**RE: Caliber Collision – 250 98th ST NW  
Erosion and Sediment Control Plan  
Engineer's Stamp Date 3/7/24 (D17E008)**

Based on the information in your submittal received on 7/19/26, the ESC plan cannot be approved until the following comments have been addressed.

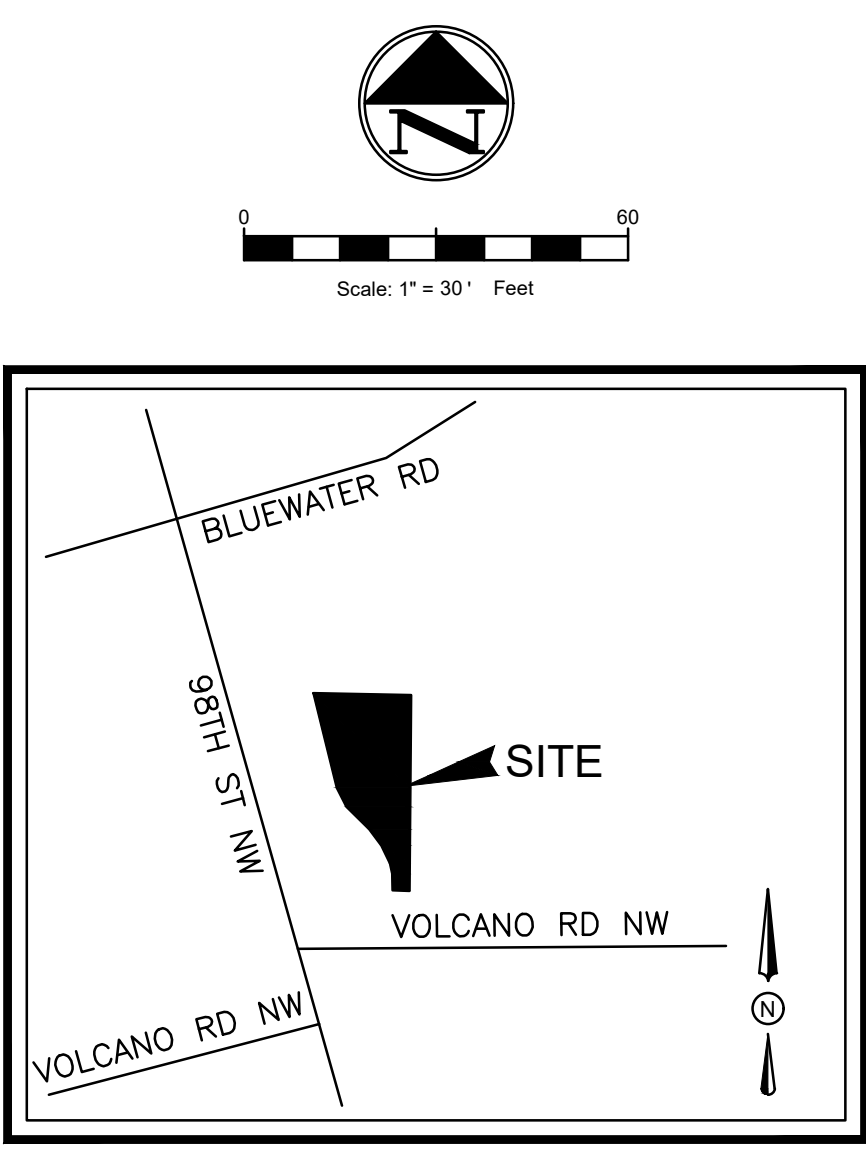
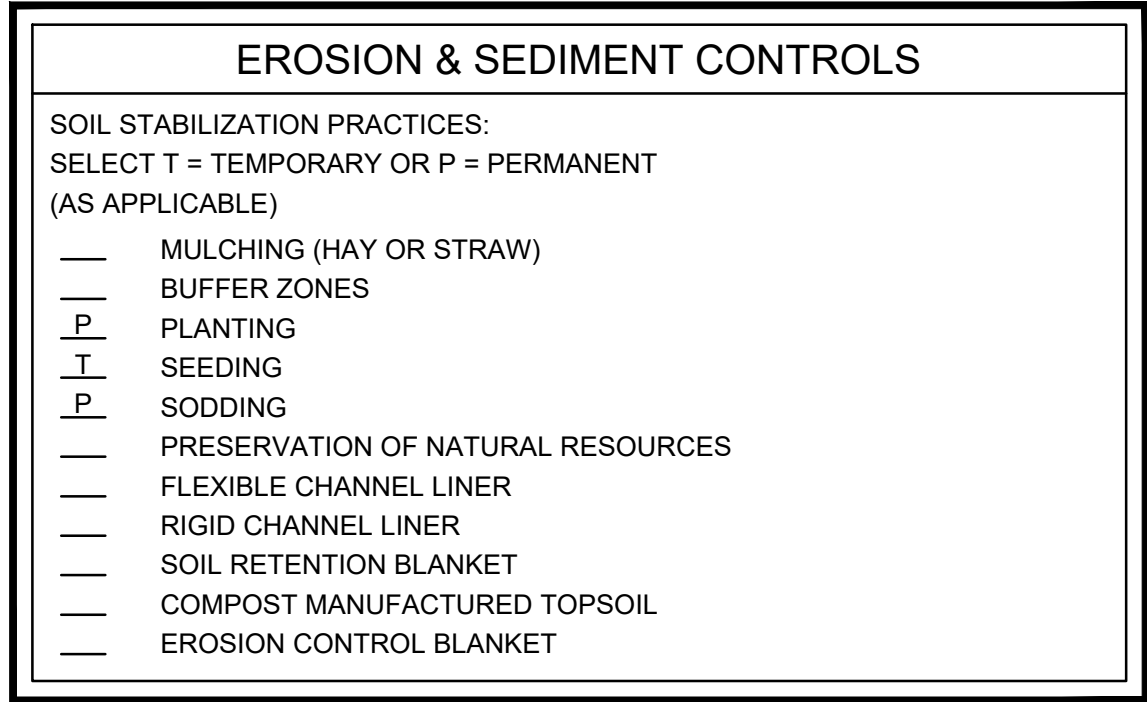
3. The Project Description in the Erosion Control Summary says "Demo Existing Building, but there aren't any existing buildings. Revise the note.
4. Note 9 in the Sequence of Construction Activities in the Erosion Control Summary does not satisfy CGP 2.2.14.c where it says "restore all disturbed areas to preconstruction use;" Change the note to agree with the requirements of CGP 2.2.14.c which requires either rock or perineal vegetation at 70% of natural undisturbed vegetation density.

5. When the current owner purchased this 2.5-acre site, it was already under construction and under CGP coverage. All construction activities by both the previous owner and the current owner must satisfy the Final Stabilization Criteria of CGP 2.2.14.c. Identify portions of the site where the previous property owner already applied ground cover that satisfies the Final Stabilization Criteria and include a description of the material used. Also, revise the Limits of Disturbance and the BMP locations to include the remaining areas to be stabilized.

6. The SWPPP must include site-specific interim and permanent stabilization per CGP 9.6.1.c.i. The Landscape Plan can be used to satisfy this requirement and should be submitted separate from the ESC Plan with the application to the Stormwater Quality Section of the Planning Department and they should be included in the SWPPP. Provide a specification on the ESC Plan for any disturbed areas not covered by the Landscape Plan.

CITY OF ALBUQUERQUE PUBLIC WORKS DIVISION ENGINEERING GROUP	
Caliber Collision EROSION CONTROL DETAILS	
DESIGN REVIEW COMMITTEE	CITY ENGINEER APPROVAL
LAST DESIGN UPDATE	MO./DAY/YR.
	MO./DAY/YR.
	MO./DAY/YR.
	MO./DAY/YR.
SHEET # 25 of 25

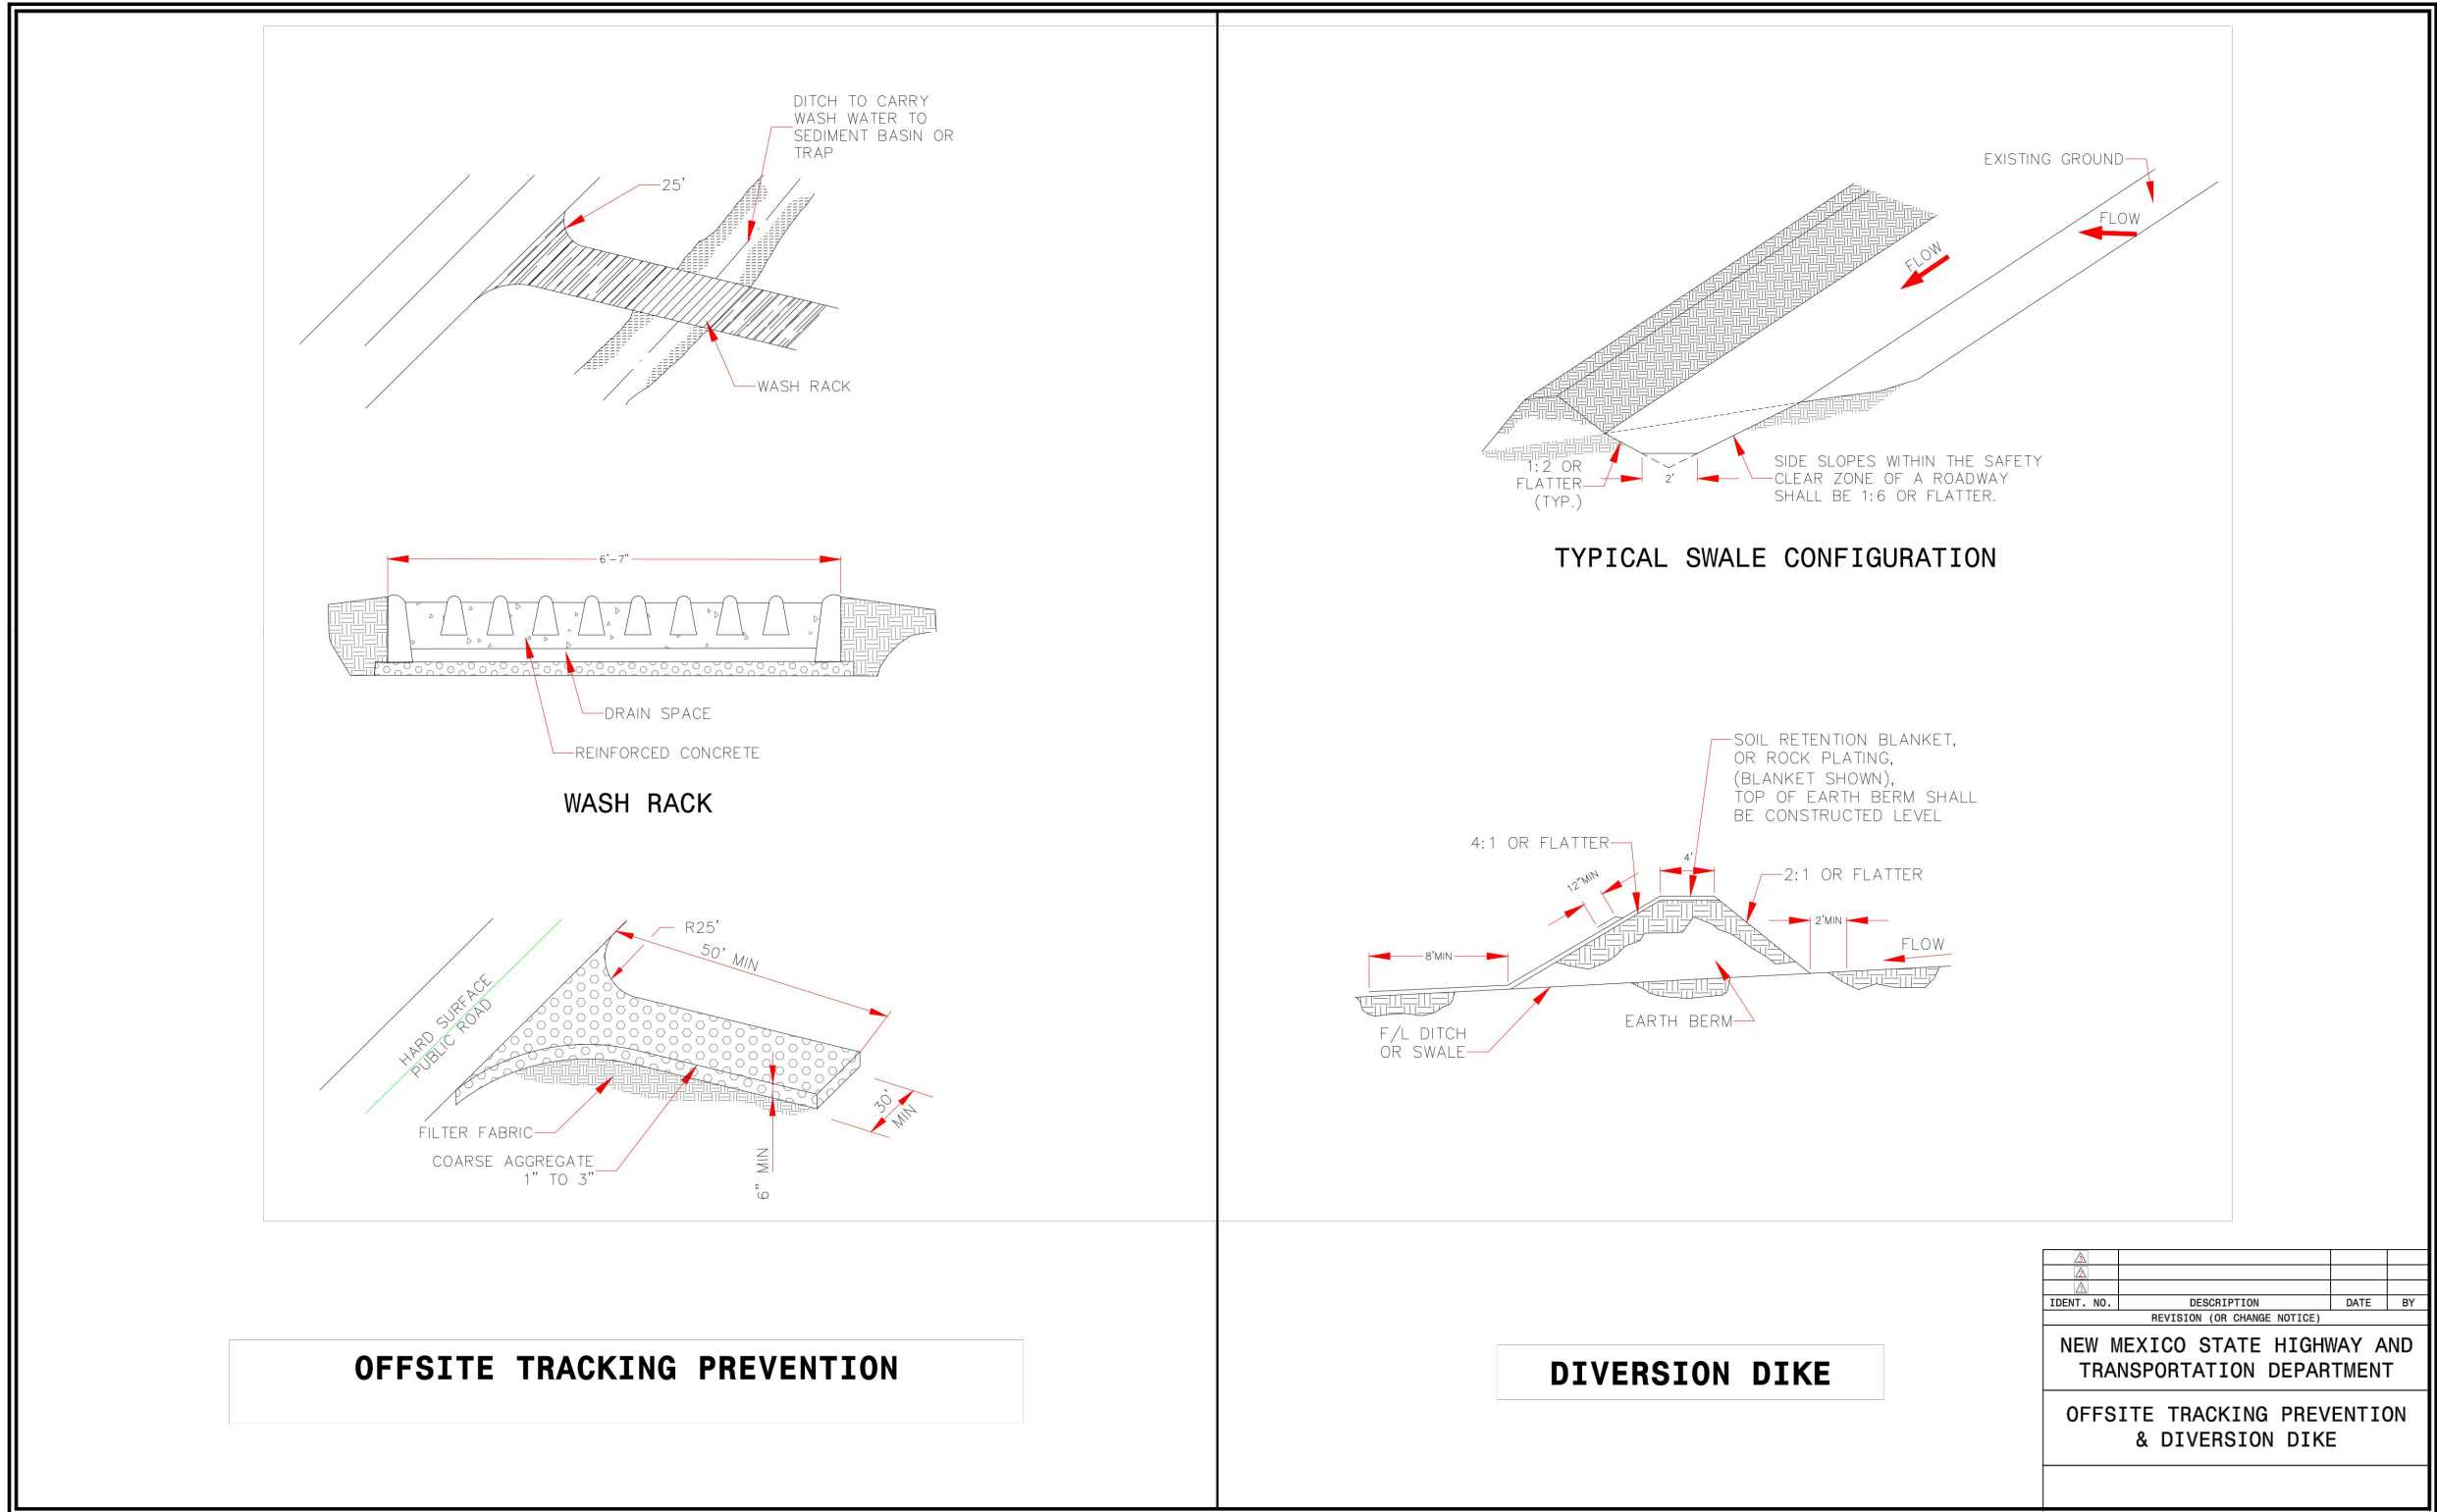
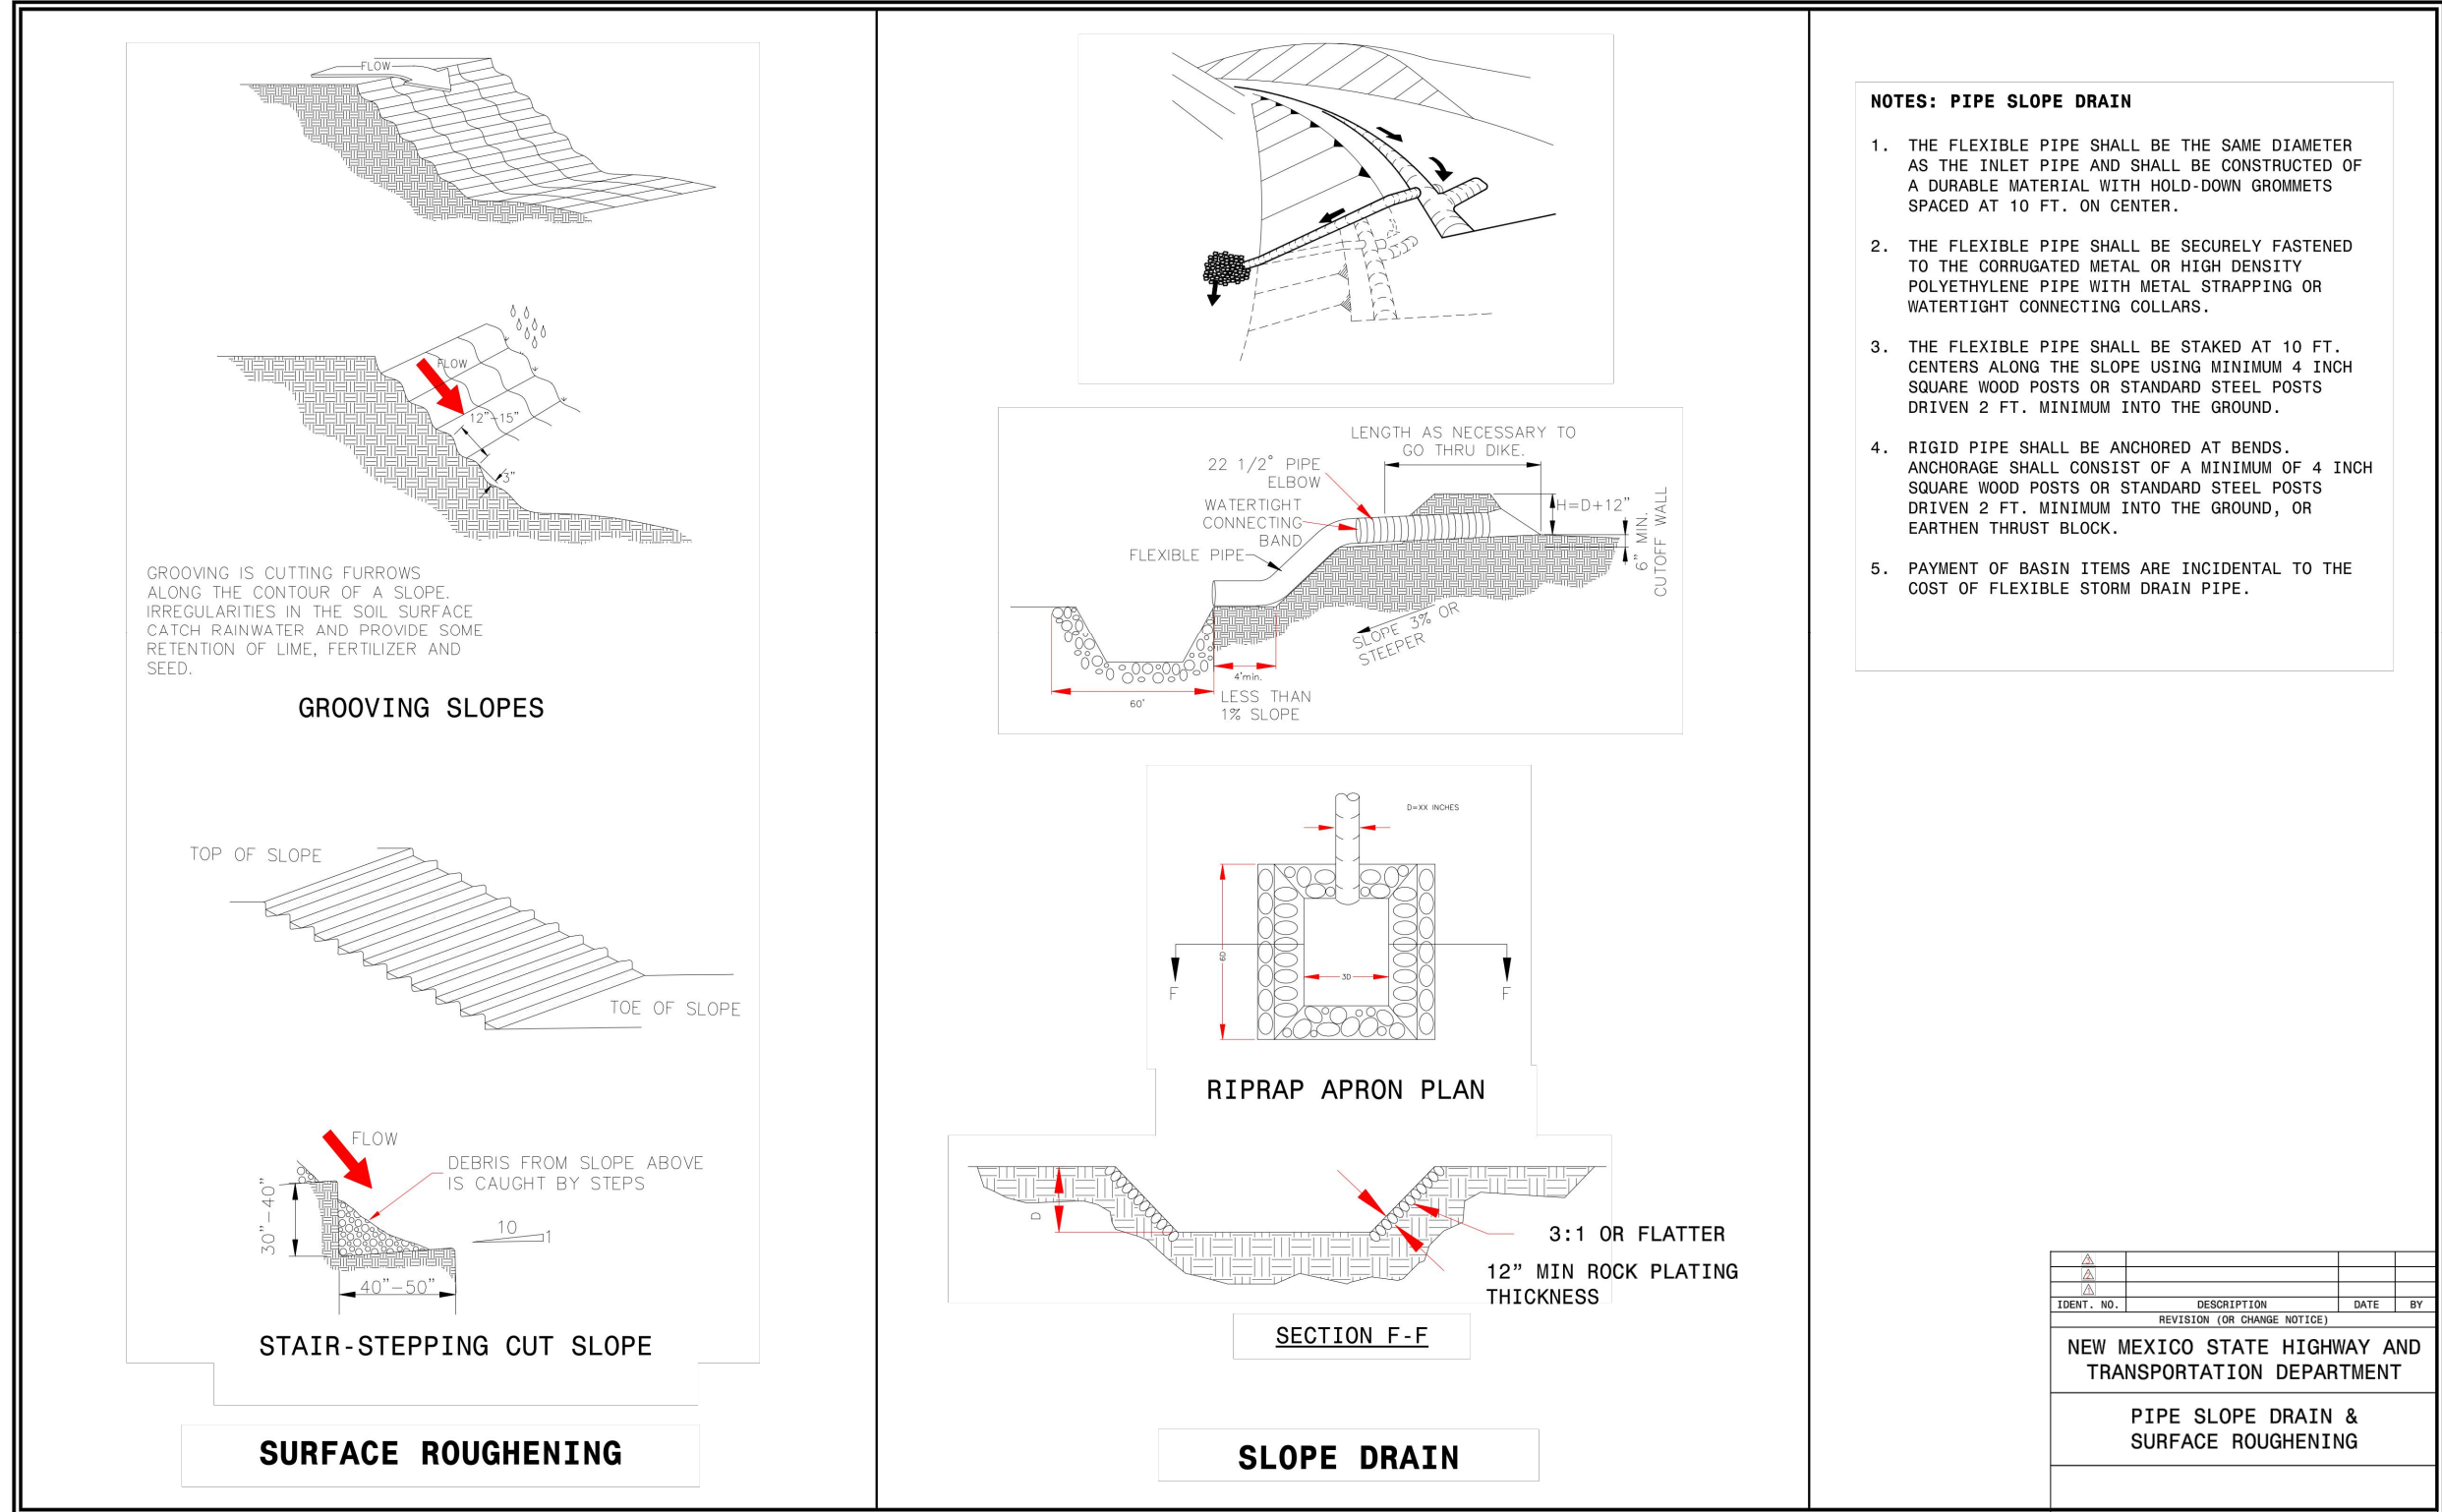
7. The Erosion and Sediment Control ESC Details are missing the construction, inspection, and maintenance specifications, as required by the city' ESC Plan Checklist and by CGP 9.6.1.c.i.
